**Gatwick Northern Runway Project DCO (Project Reference: TR020005)**

**Deadline 8 Submission (7 August 2024)**

**Joint Surrey Councils – Surrey County Council (Ref. 20044665), Mole Valley Borough Council (Ref: 20044578), Reigate and Banstead Borough Council (Ref. 20044474) and Tandridge District Council (Ref: 20043605)**

**Overview**

Title
Gatwick Business as Usual (BaU) Signalisation Scheme Concept Design APFP Regulations 5(2)(q) - Sheet 1 Highway Layout Plans - North Terminal

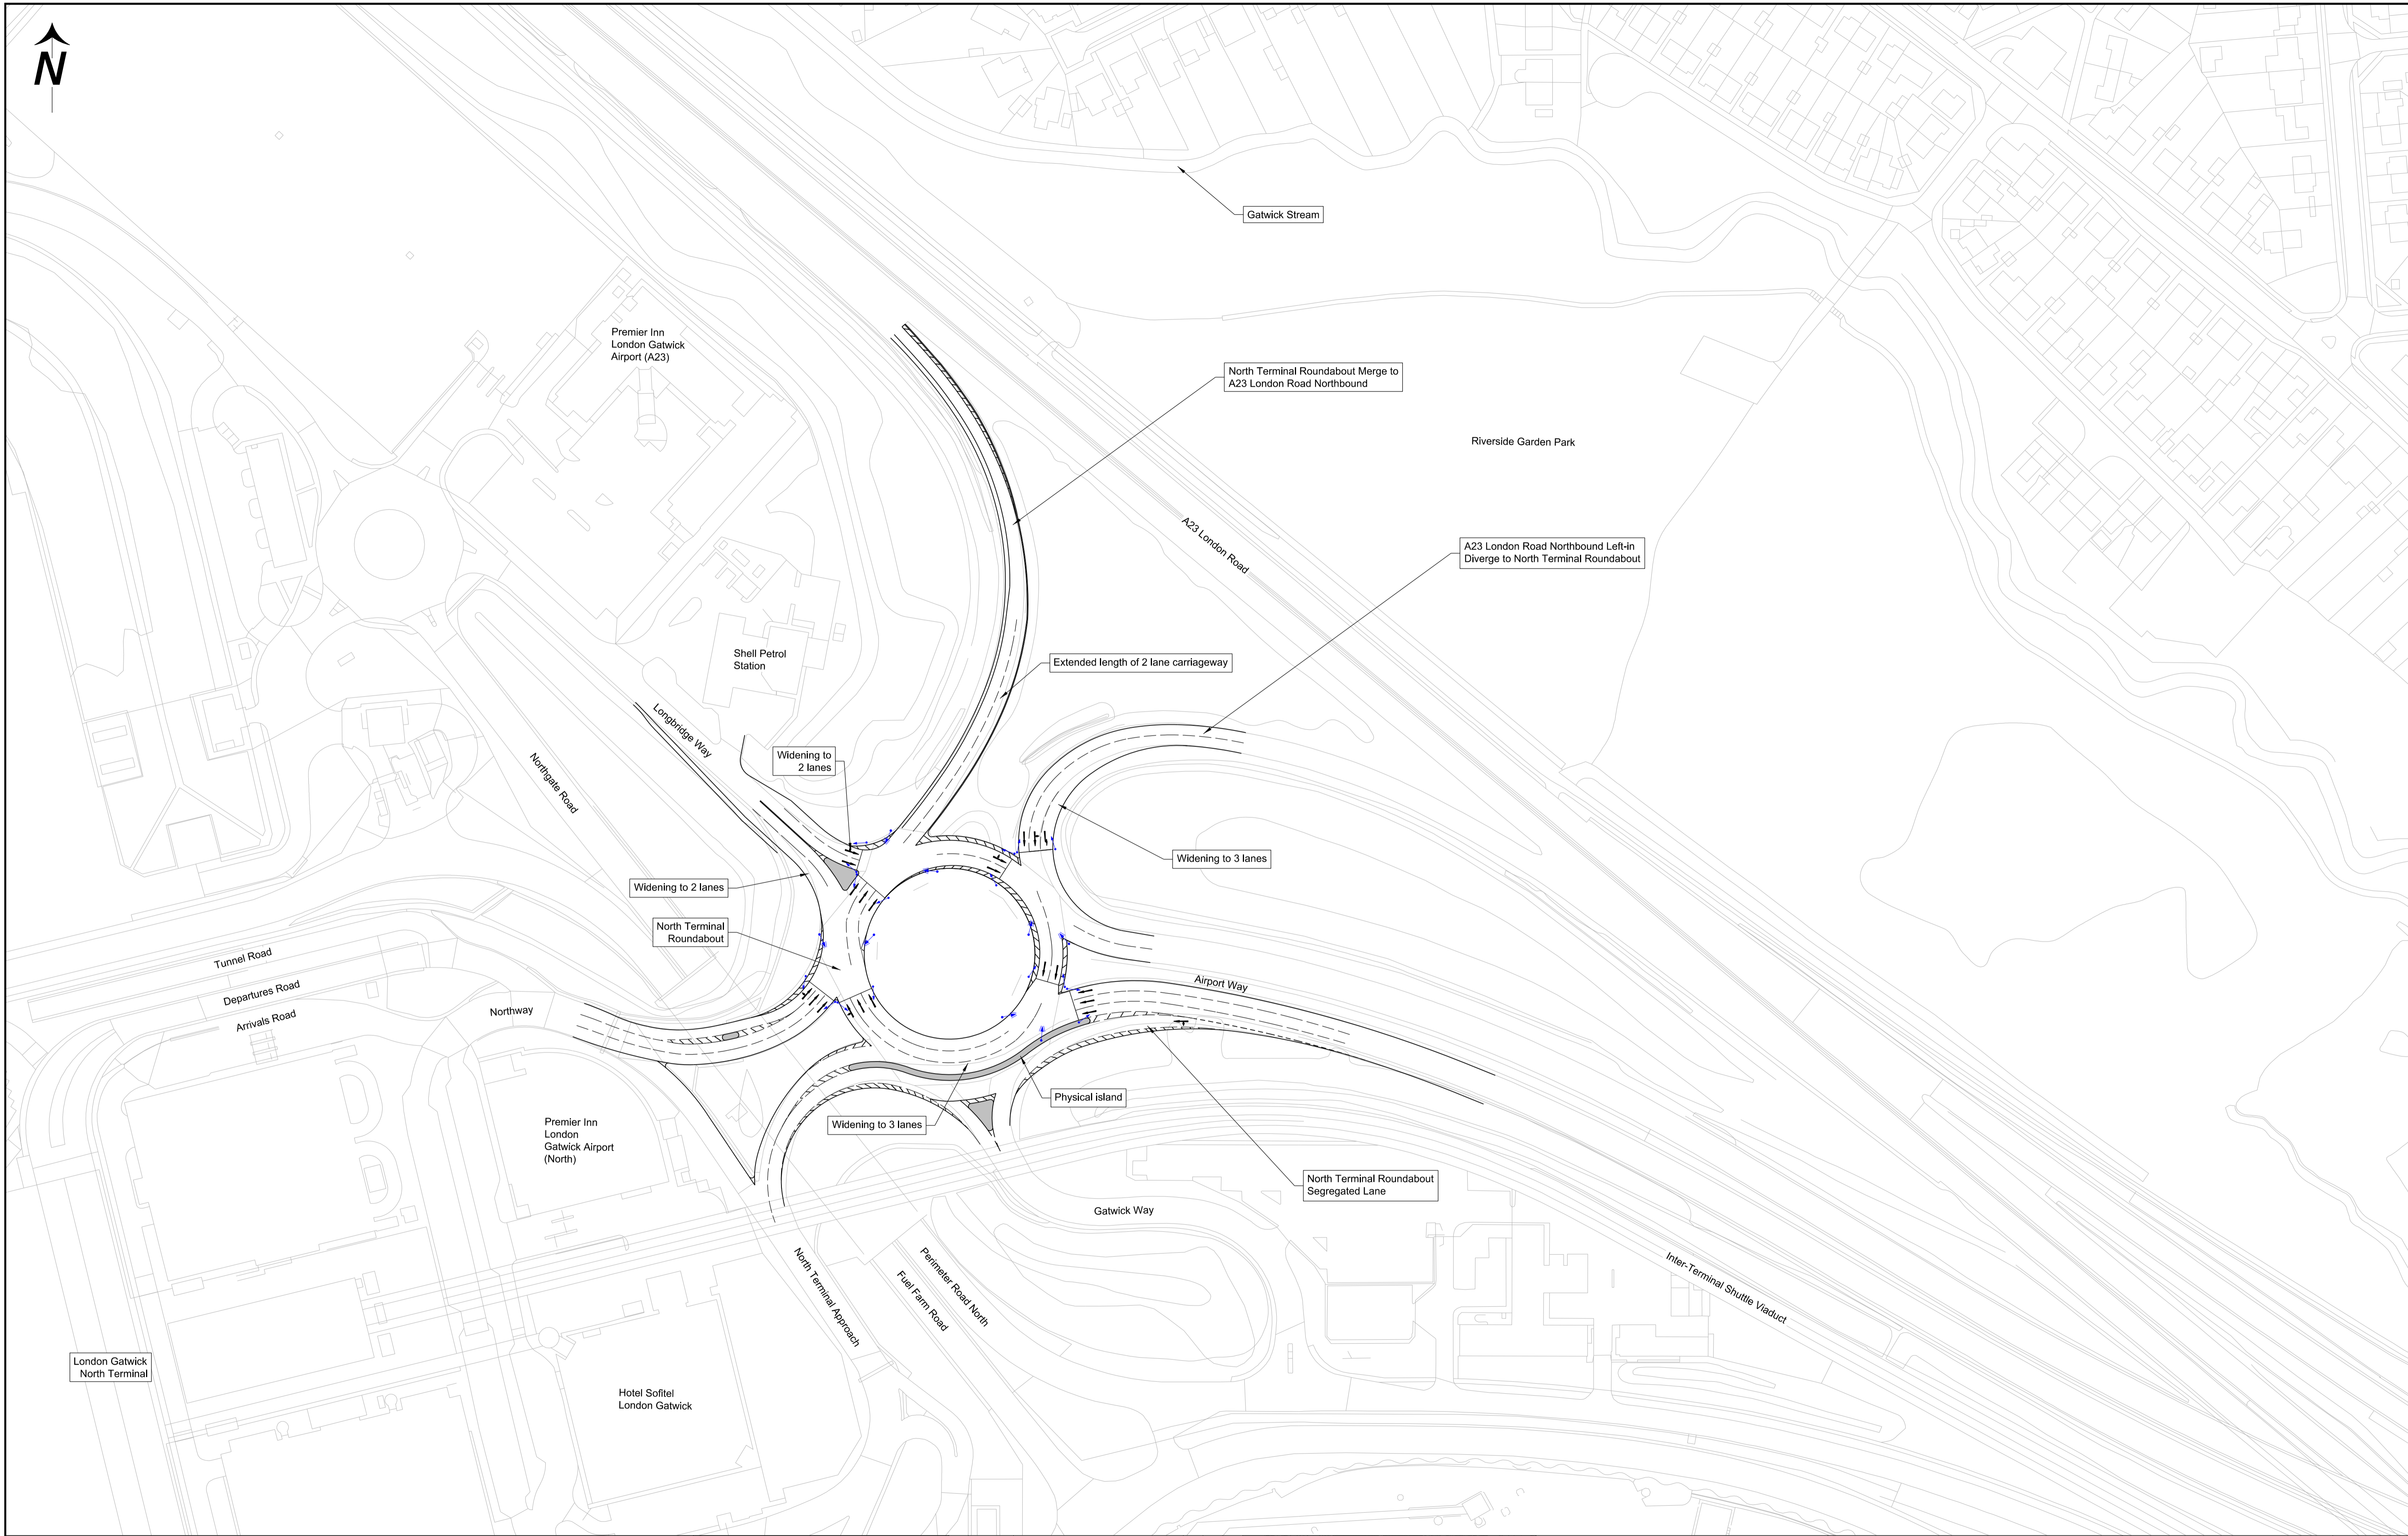
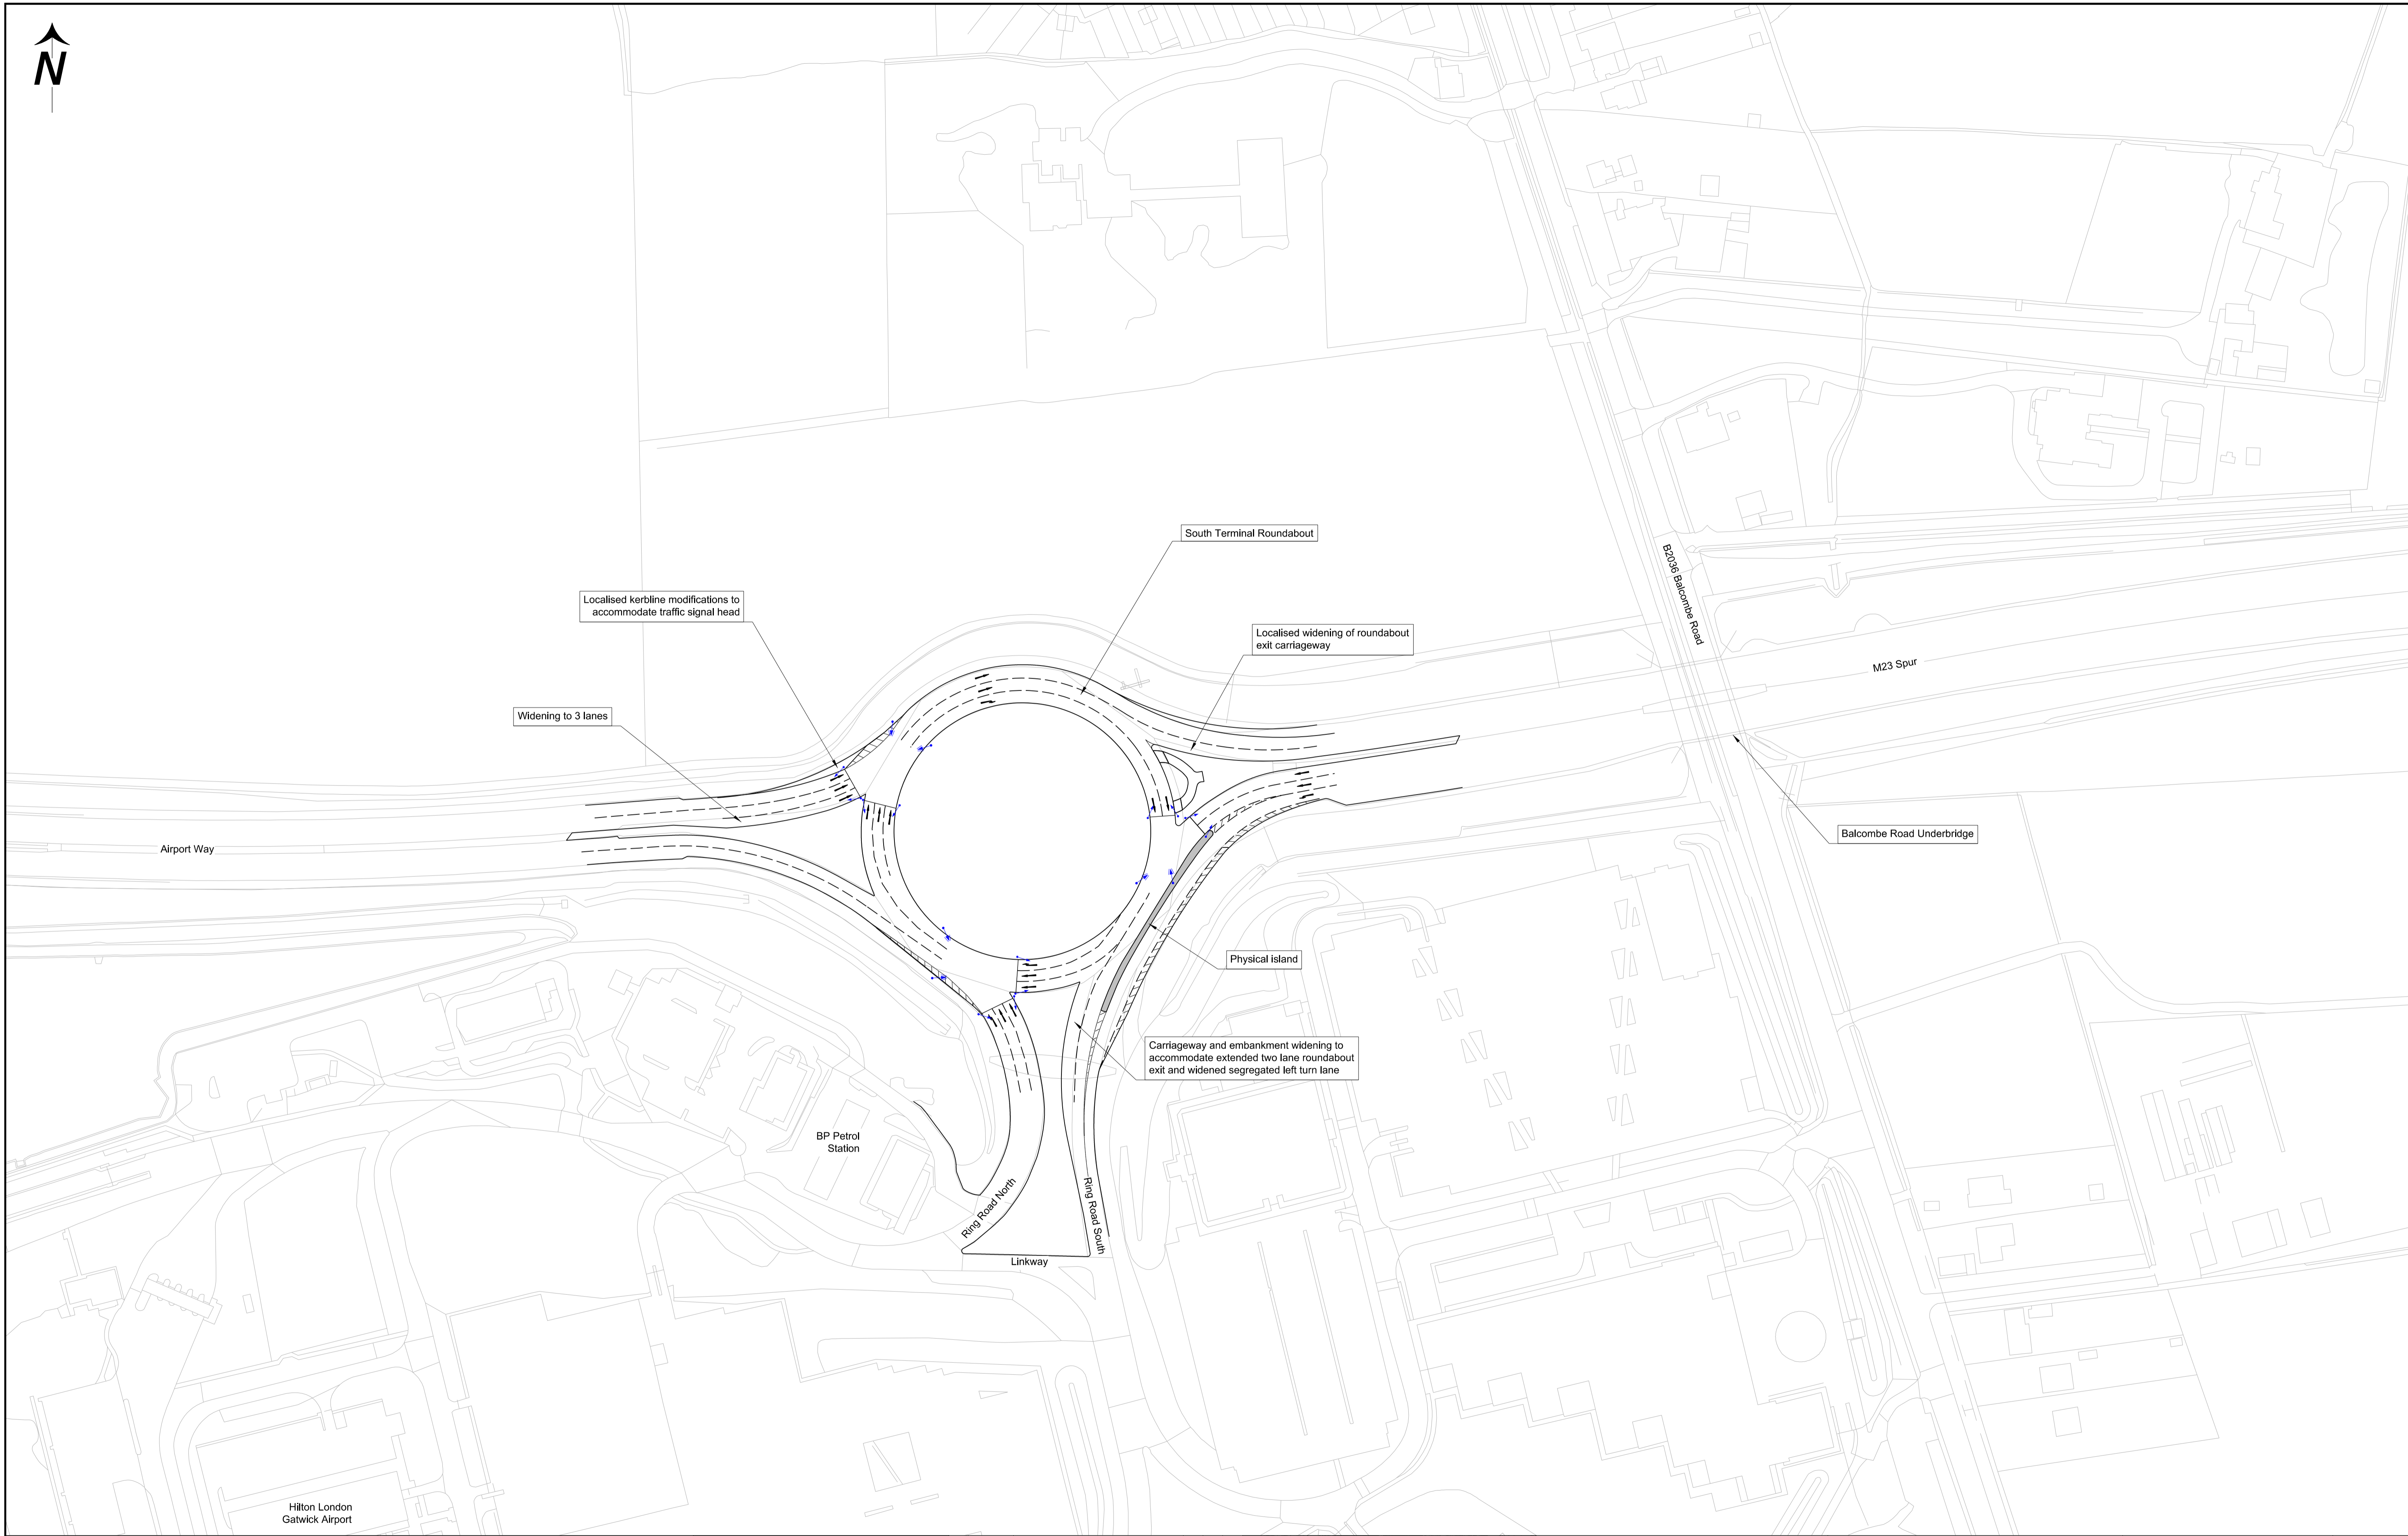
17. In response to question TT2.12, SCC agrees with National Highways that a crossing provision where Footpath 346\_2sy intersects with North Terminal Roundabout at Longbridge Way and Northway would be beneficial as part of the overall Active Travel proposals.
